**BARANGAROO SOUTH,
C3 COMMERCIAL BUILDING**

ACCESS REVIEW

Morris-Goding Accessibility Consulting

16 September 2011

Drawn/Checked by
AII/LF
Drawing Title
Plan
First Floor
Level 1 (+9.000 FFL)

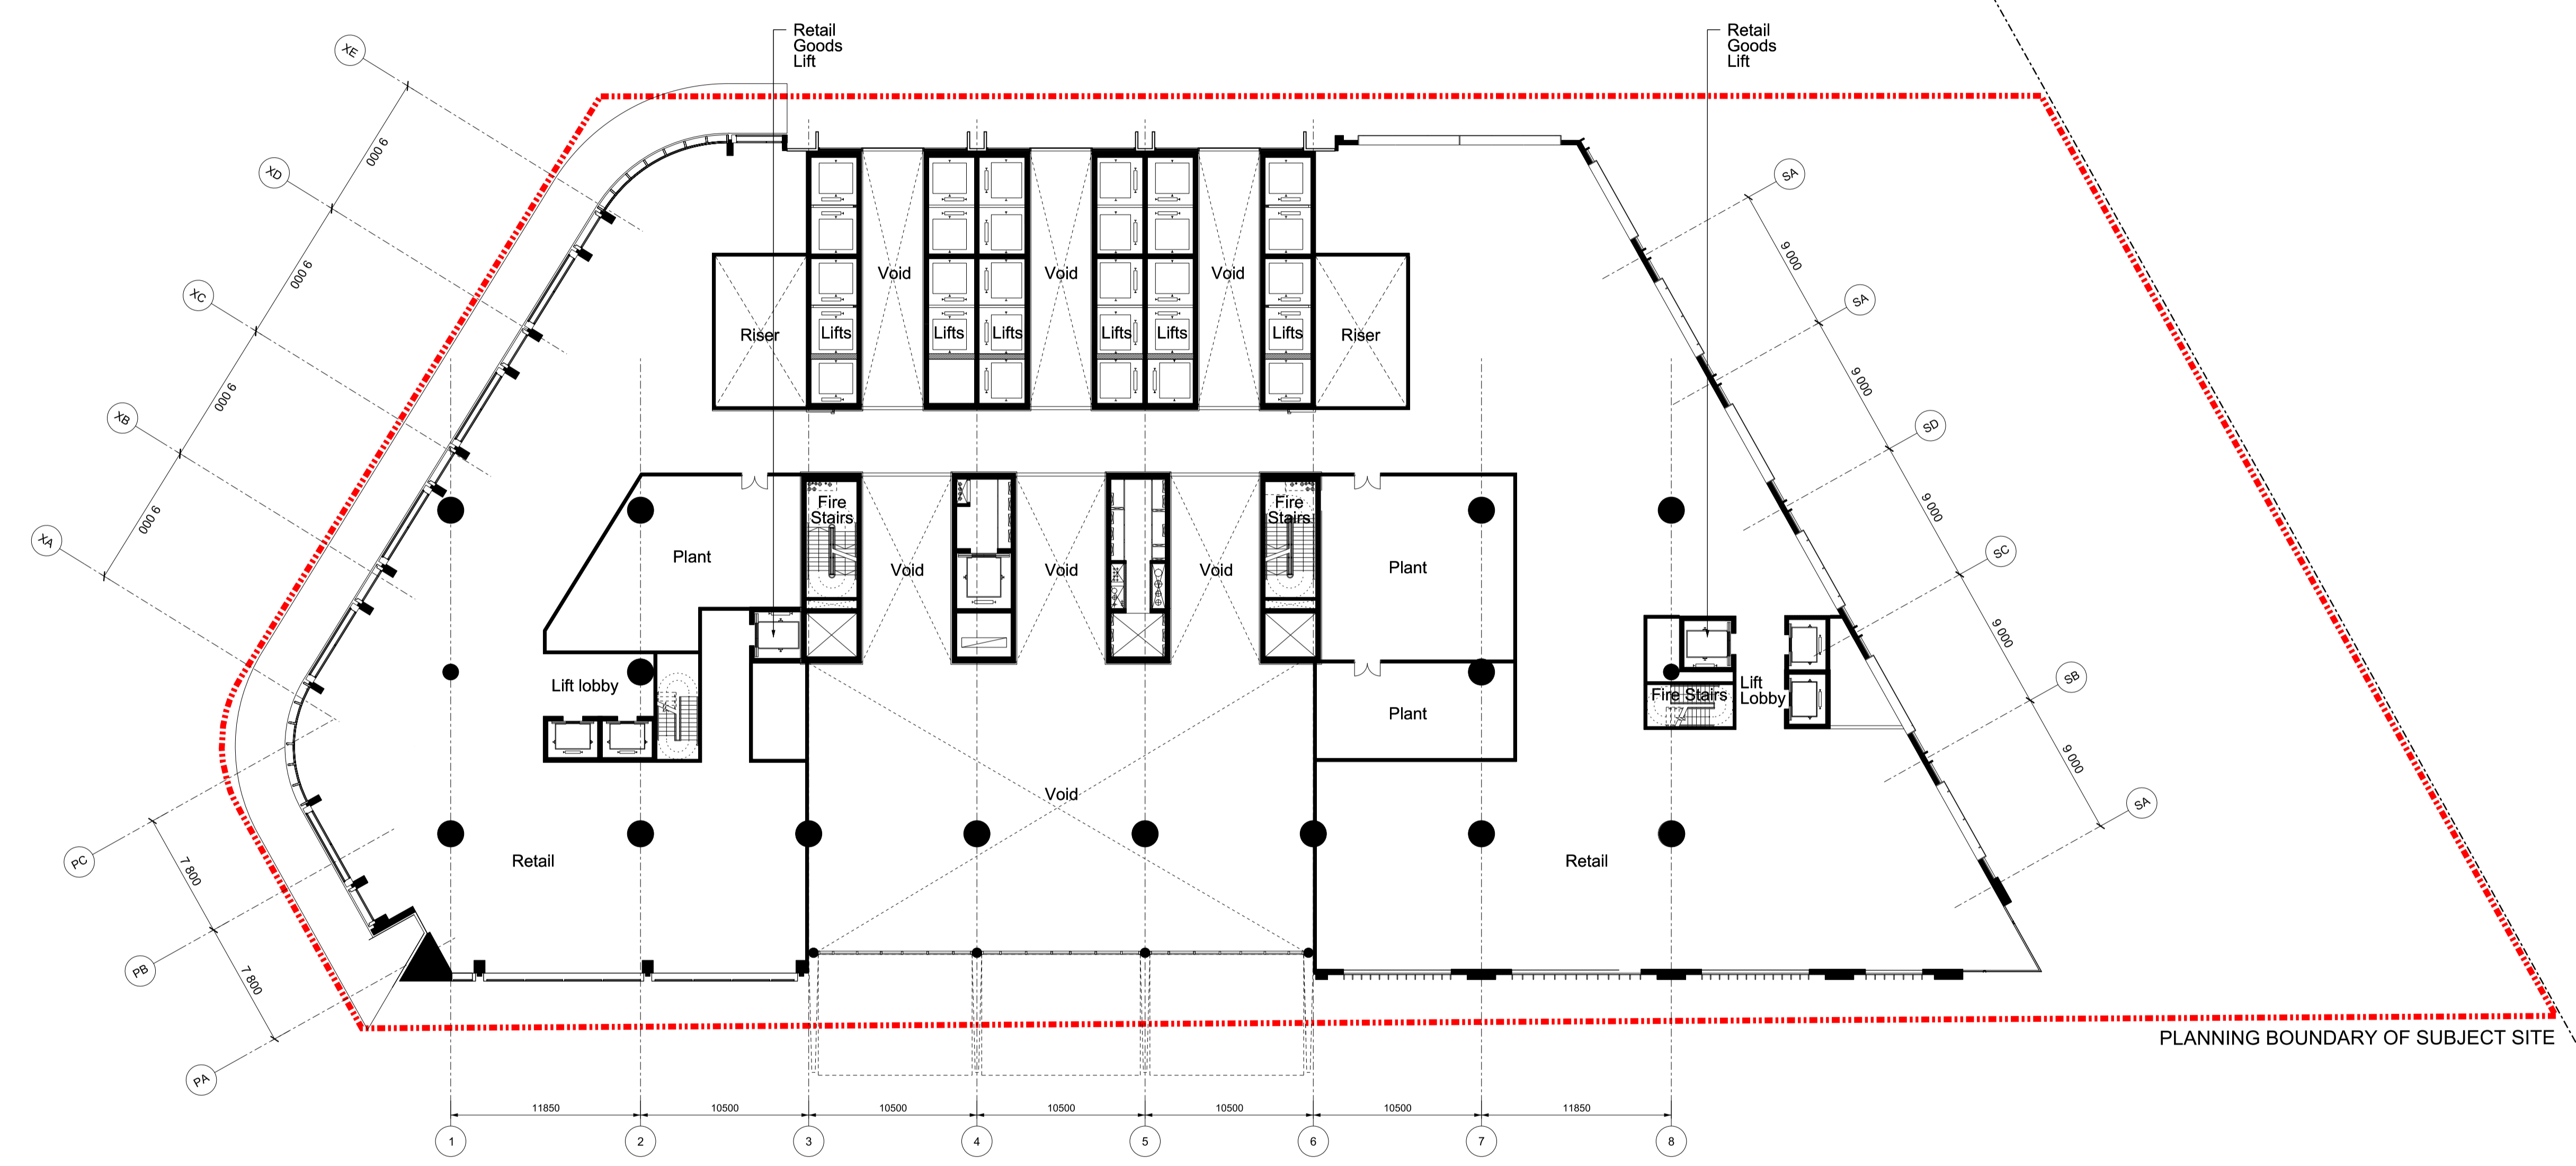
There are accessible paths of travel leading to 2 x lifts from plan east side of the building. These lifts access the retail/restaurant on level 1 and childcare on level 2. Both tenancies on level 1 and level 2 have continuous paths of travel throughout.

The retail area on level 1 (plan west side) can be accessed via 2 passenger lift cars from the retail area on ground floor. This would be appropriate as long as both ground and 1st floor retail areas would be leased as a single tenancy.

- (i) The childcare on level 2 (plan west) would need separate lift access as current access to the passenger lift is via the retail tenancy on ground floor.
